**August 26, 2009**

**DRB Comments**

**PROJECT # 1004241**

**RE: Lot 7-A, Block C, Highland Addition South**

BUILDING H
SCALE: 1"=10'

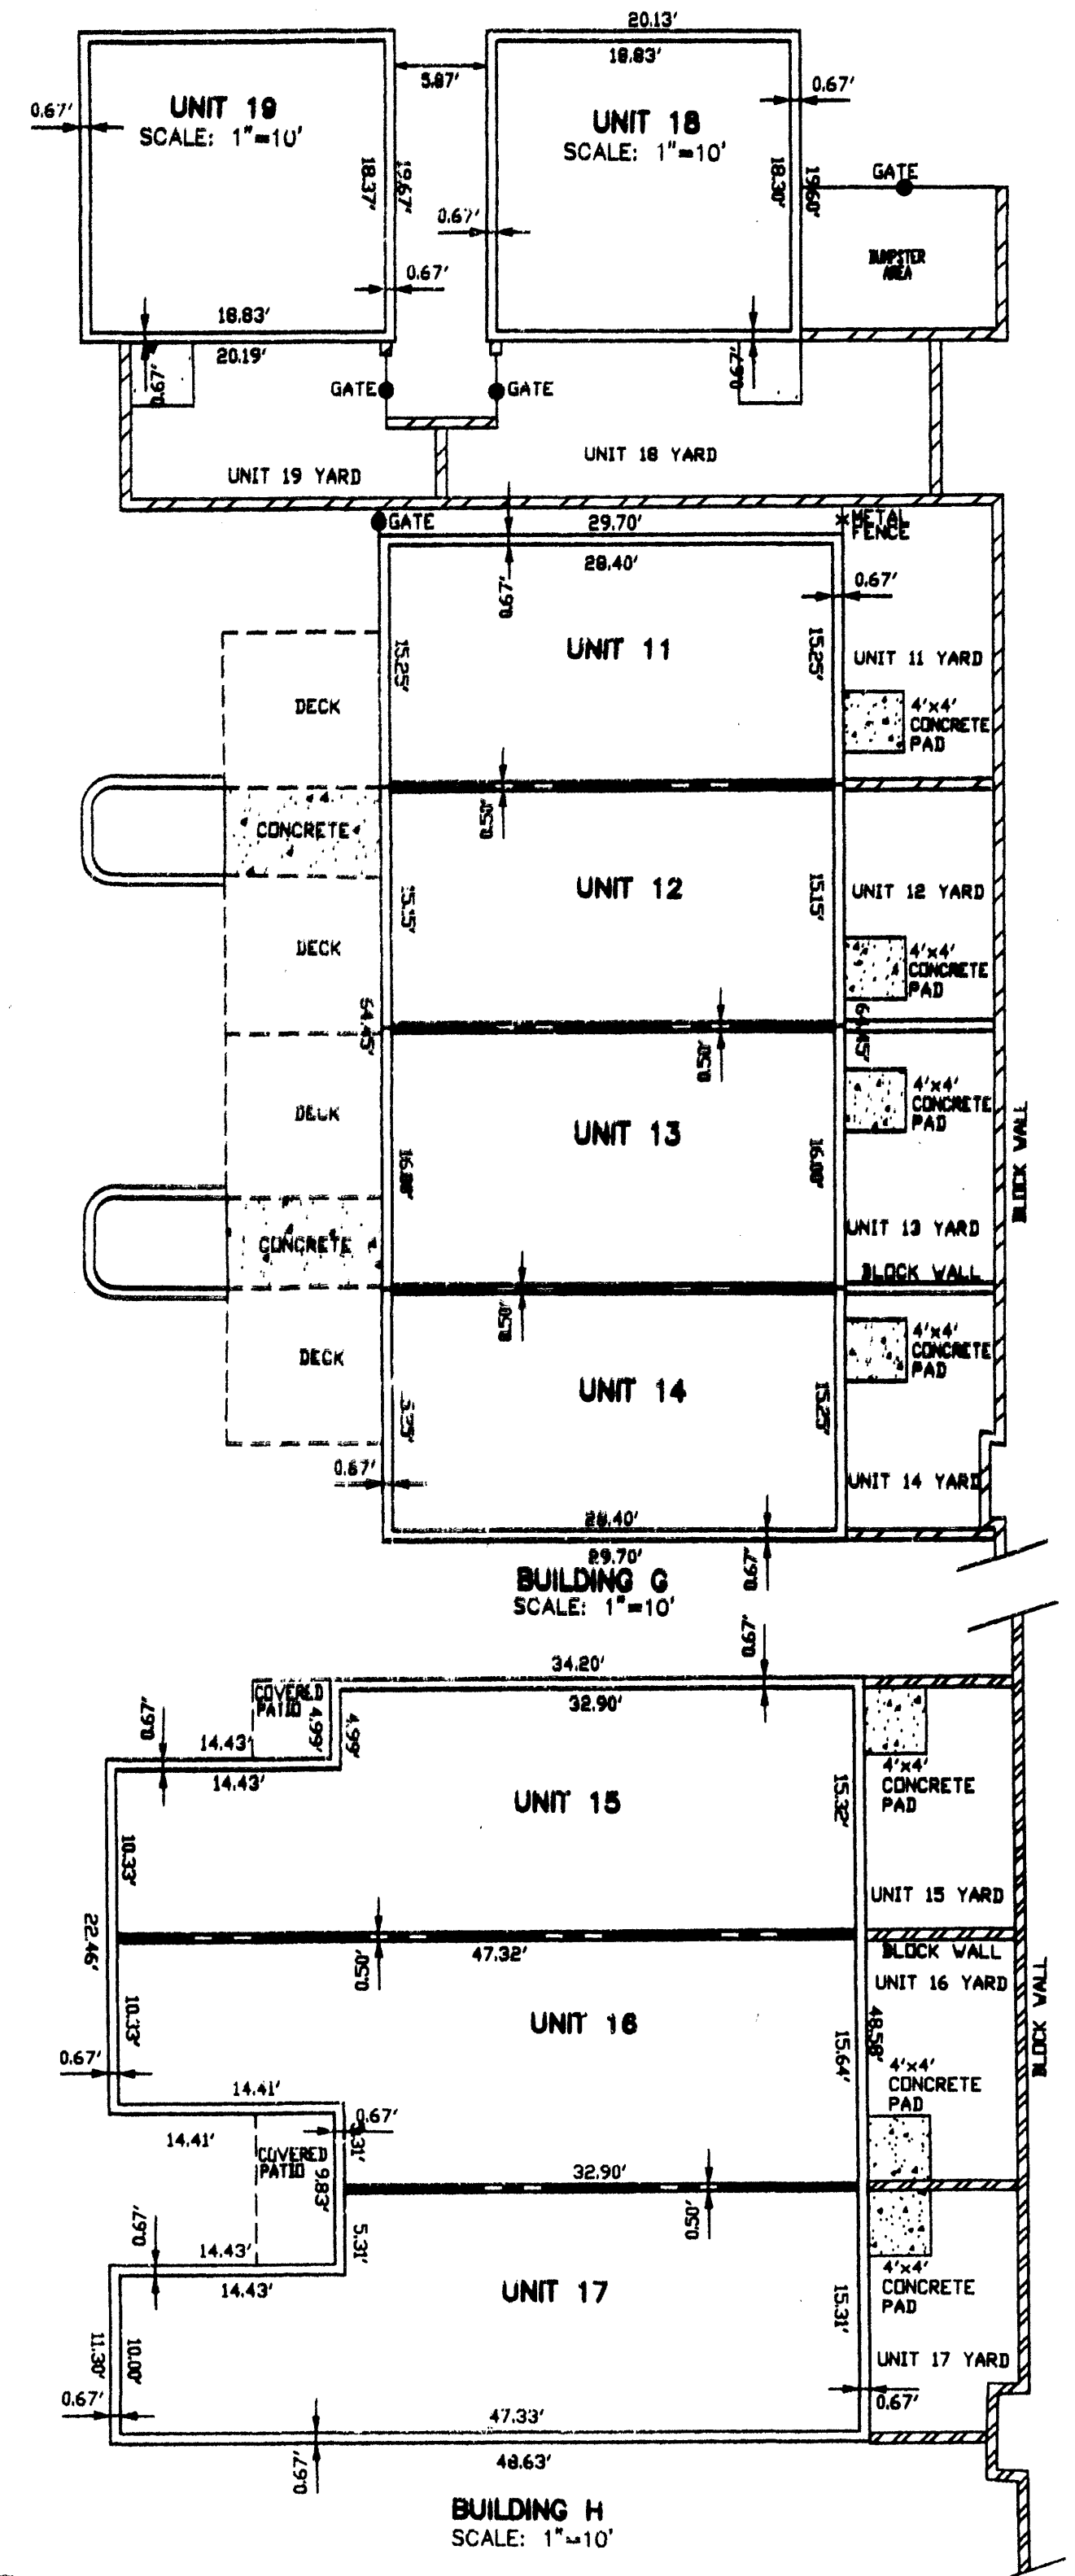
The site is zoned SU-2/ NCR and is within the South Broadway Sector Development Plan area; R-2 regulations generally apply for residential development, which refers to the RT zone for townhouses with a minimum 22 foot lot width and 2,200 square foot lot area. The proposed townhouse subdivision would require variances from both width and area requirements prior to application for subdivision approval. Additionally, common building walls would need to be certified to meet building code requirements for attached dwellings prior to application. Finally, "Landscaped Areas" might be more appropriately platted as easements over adjacent lots.

This would be classified a major subdivision by the Subdivision Ordinance, and would require an advertised public hearing by the Development Review Board.
